**KIRKLEES METROPOLITAN COUNCIL
INVESTMENT & REGENERATION SERVICE**

Reference No:	2026/62/90574/W
Site Address:	37, Sylvan Ridge, Huddersfield, HD2 1ZH
Description:	Demolition of existing conservatory and erection of part first floor/part two storey side extension, two storey rear extension and loft and garage conversion with associated alterations
Recommending Officer:	Nicole Helliwell

Officer Report

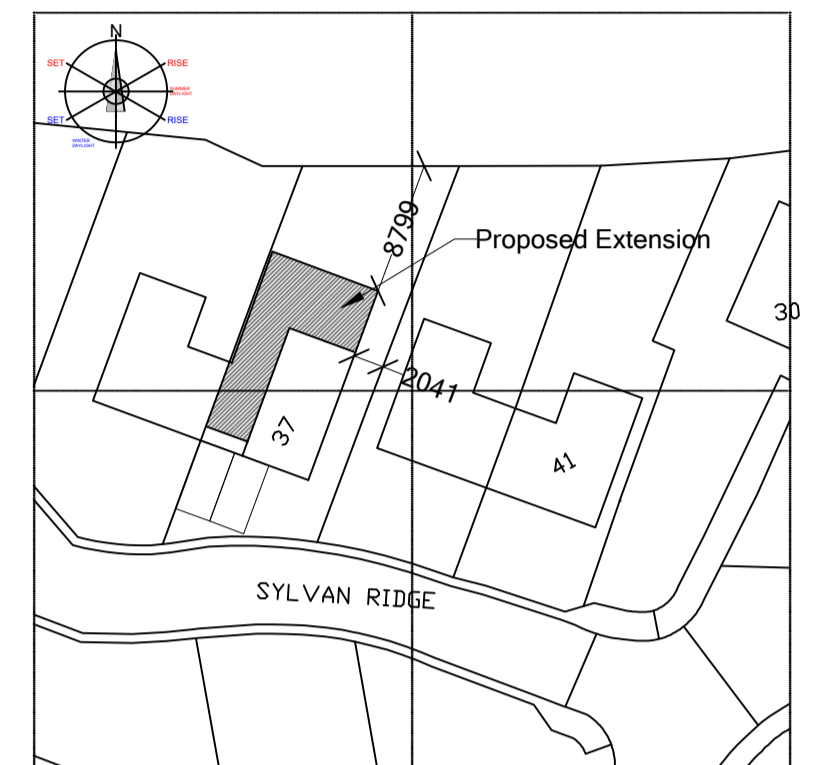
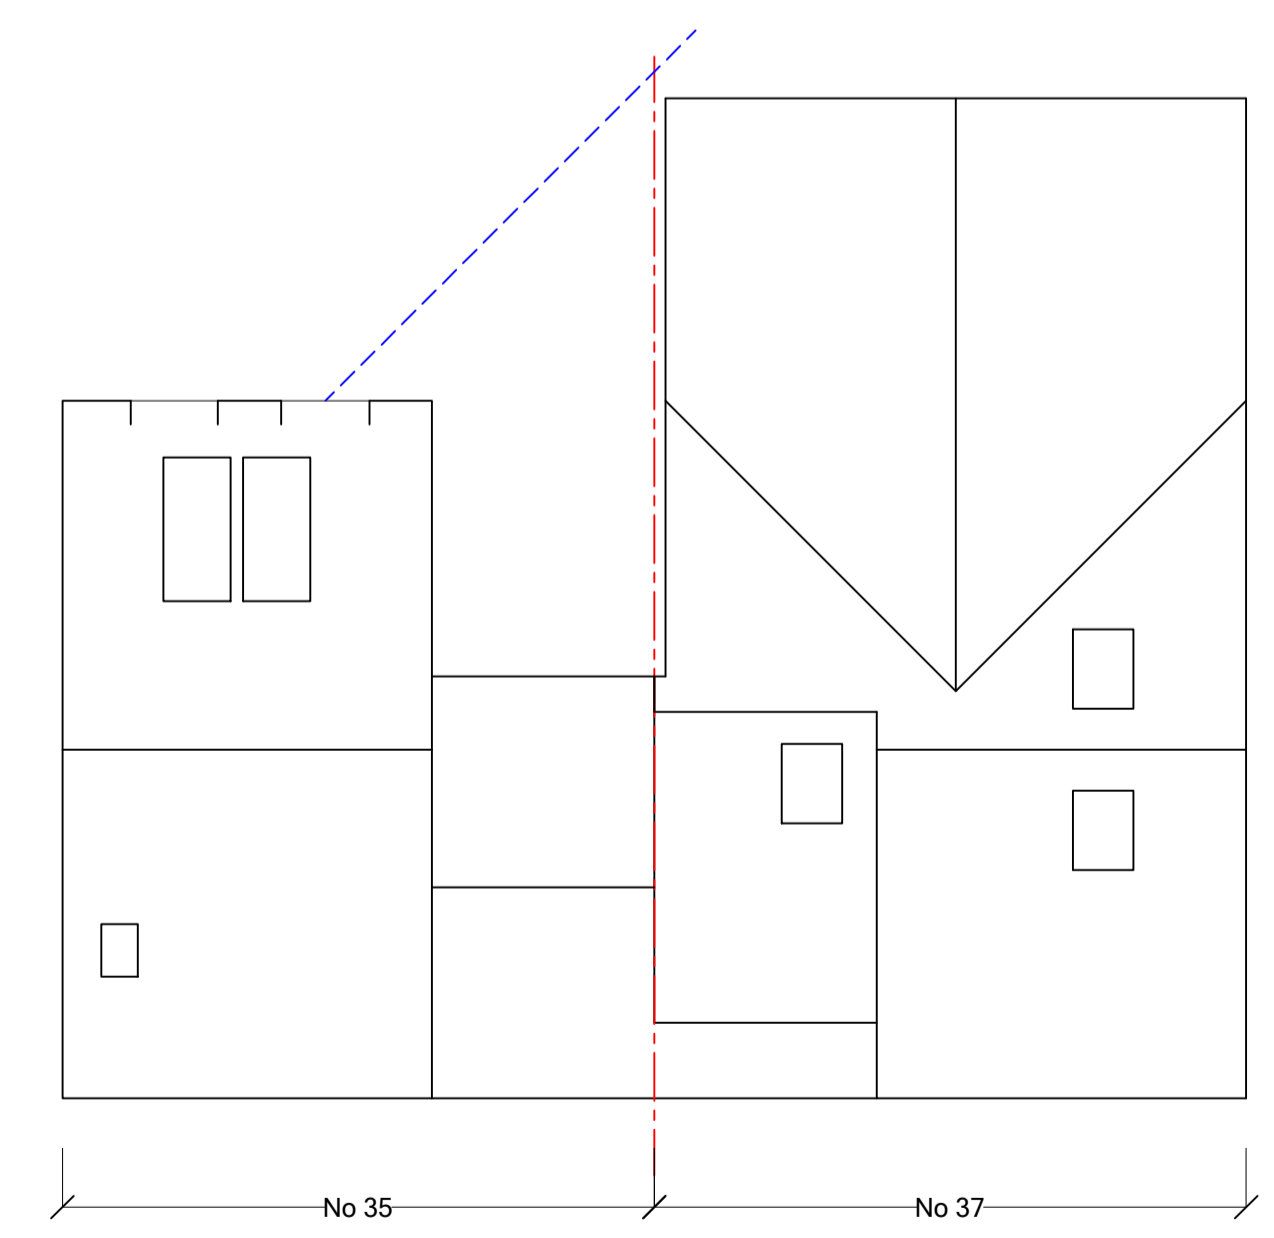
39 Sylvan Ridge is a two-storey semi-detached property located east of the application site. The submitted site plan demonstrates that proposed two-storey rear extension would occupy a position approximately 2m from the common boundary shared with the neighbouring property. Whilst the enlargement would surpass the rear elevation of no.39, it would accord with the 45 degree rule in relation to the neighbour's rear fenestration. Therefore, it is considered that the proposed development would not cause any additional overbearing or overshadowing harm to the residential amenity of the neighbouring occupants, over and above the existing arrangements on site.
